PLANNING DEPARTMENT
DEVELOPMENT SERVICES DIVISION
600 2nd Street NW, Ground Floor, 87102
P.O. Box 1293, Albuquerque, NM 87103
Office (505) 924-3946

OFFICIAL NOTIFICATION OF DECISION

Project# PR-2022-007103
Application#
SI-2024-00922 EPC FINAL SIGN-OFF

1. This is a request for a new light and heavy vehicle fueling station with incidental convenience store uses, such as retail and restaurant. The existing fueling depot on the southern 15-acre portion of the site will remain as developed and is included in this request as an As-Built Site Plan.

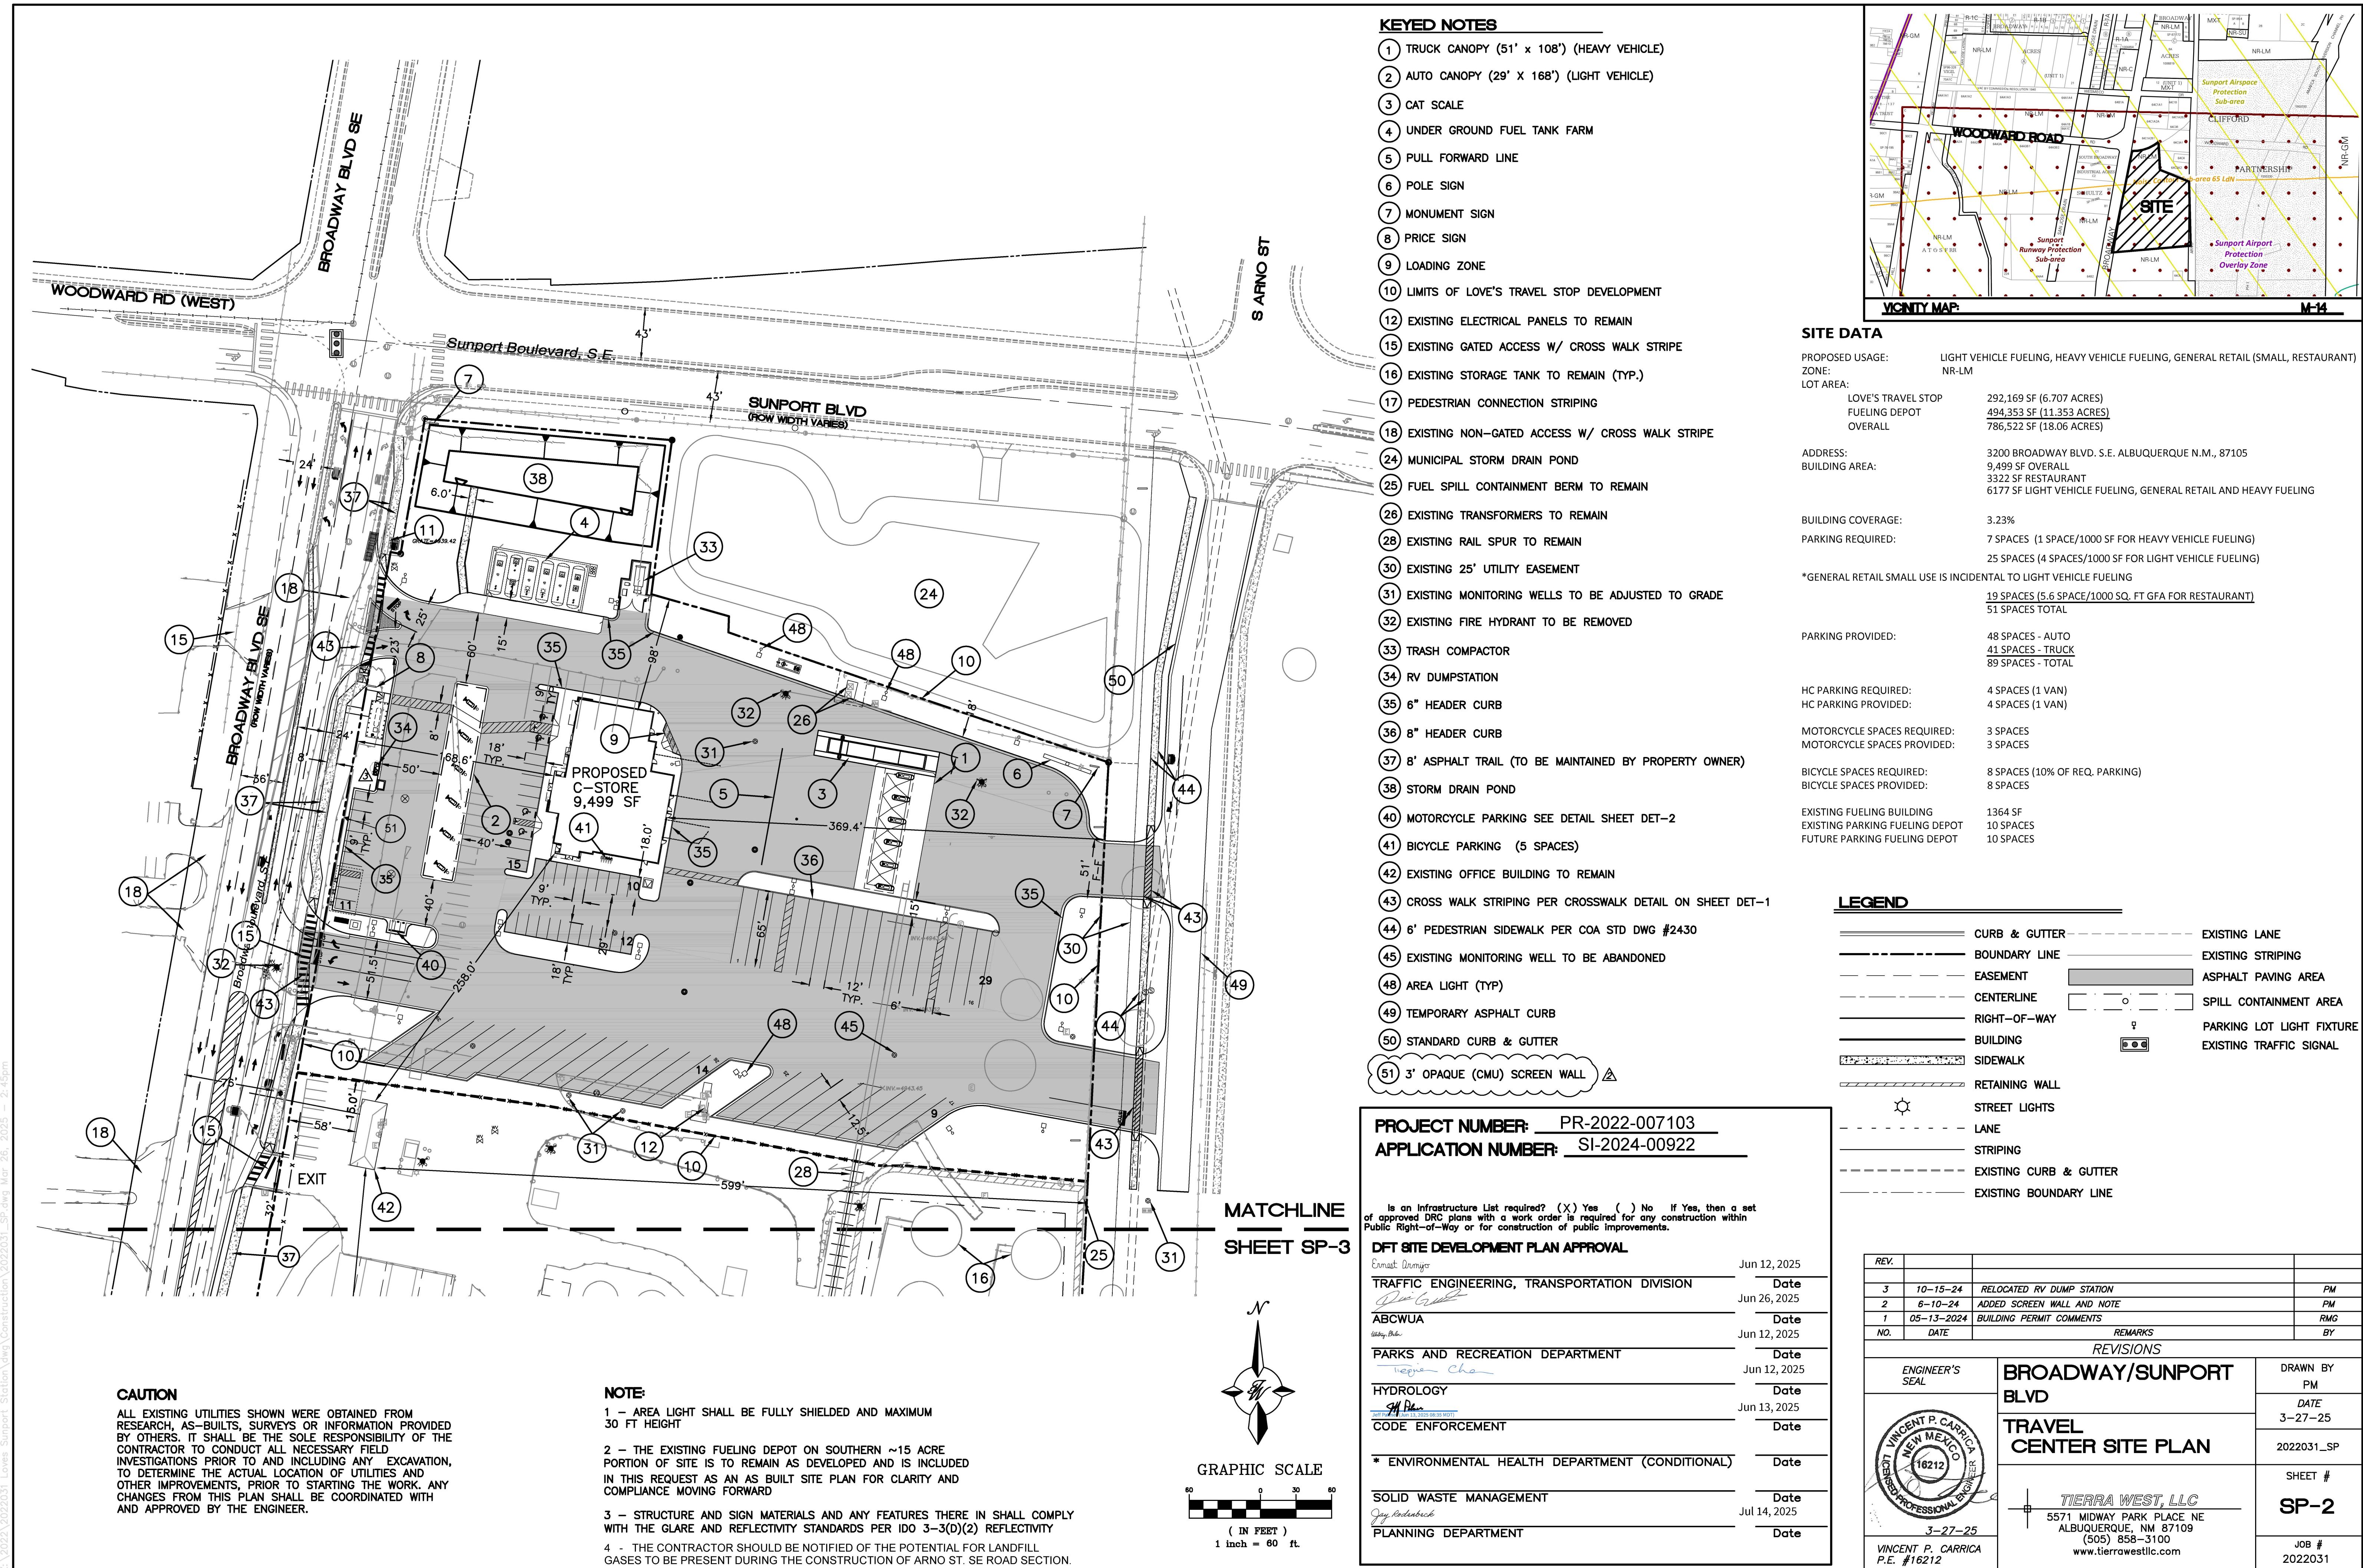
2. Correct the maximum pole height of light poles on the Site Plan per 2022 IDO requirements.
3. Add the following note to the Site Plan: The contractor should be notified of the potential for landfill gases to be present during the construction of the Arno St. SE road section.
4. Recorded IIA must be submitted.
5. Recorded Access Easement must be submitted.

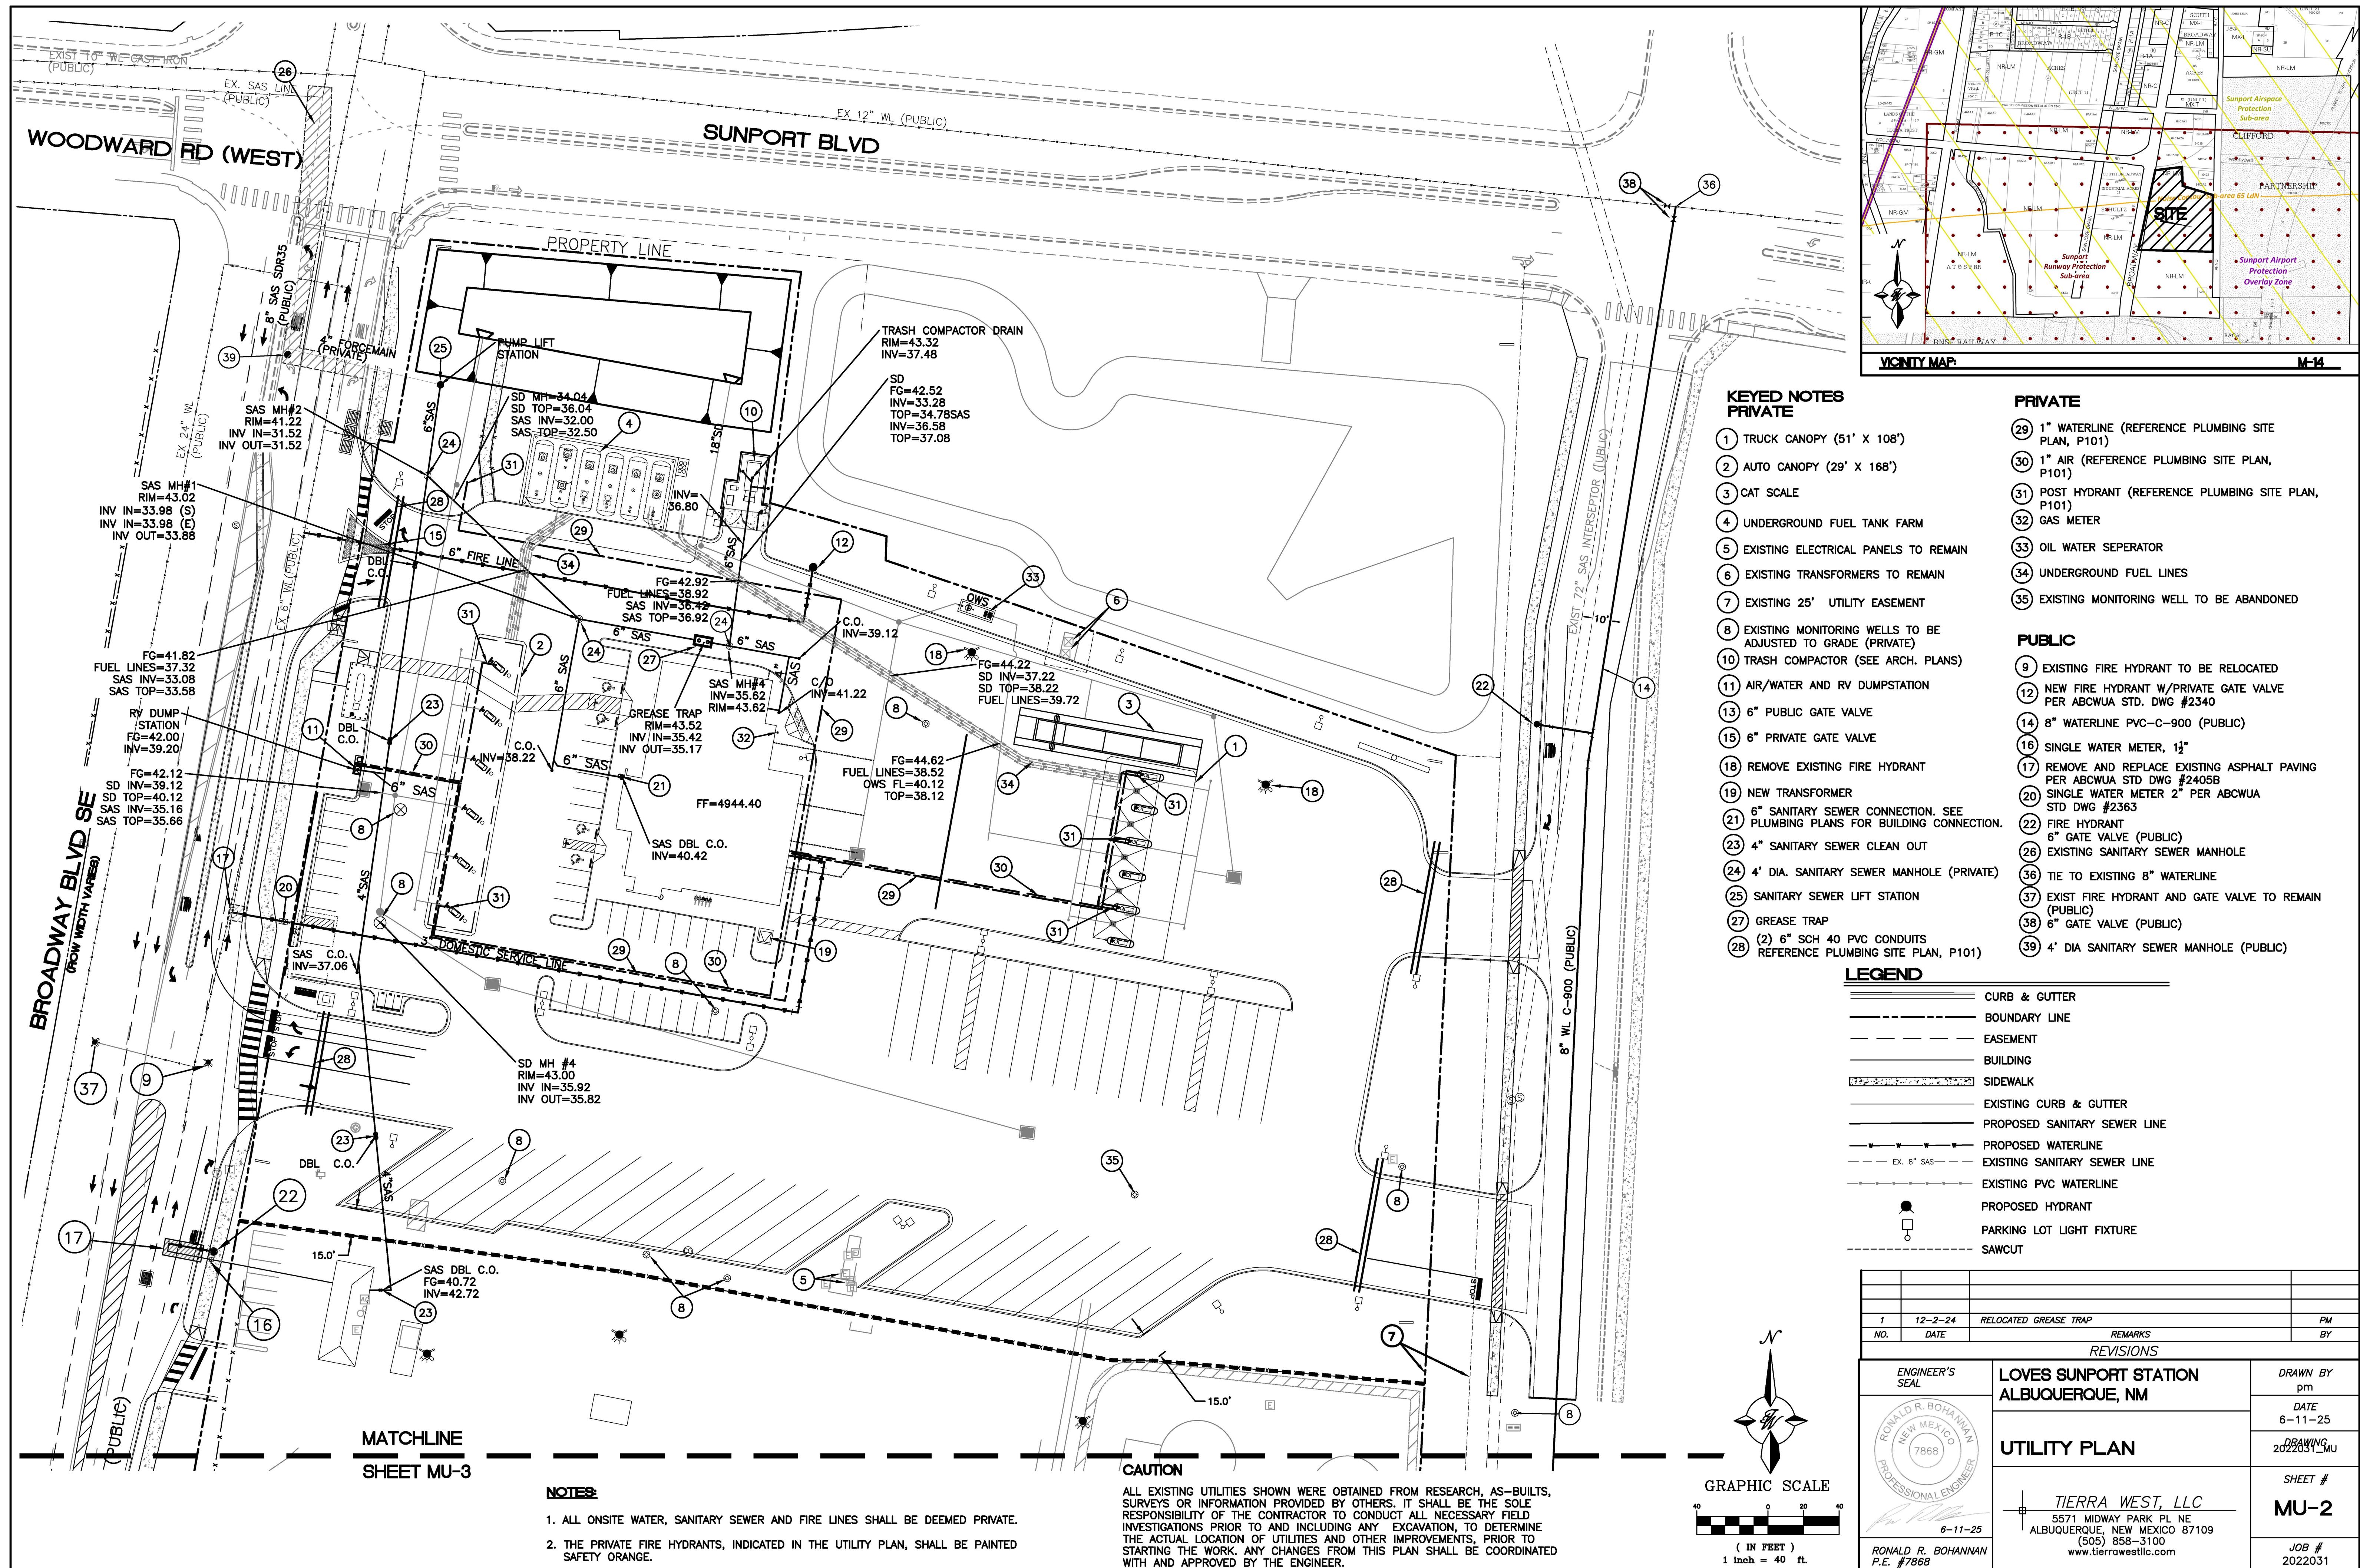
1. Separate public and private infrastructure keyed notes and verify the removed hydrant is not necessary to remain for adjacent developments and proper spacing per DPM.
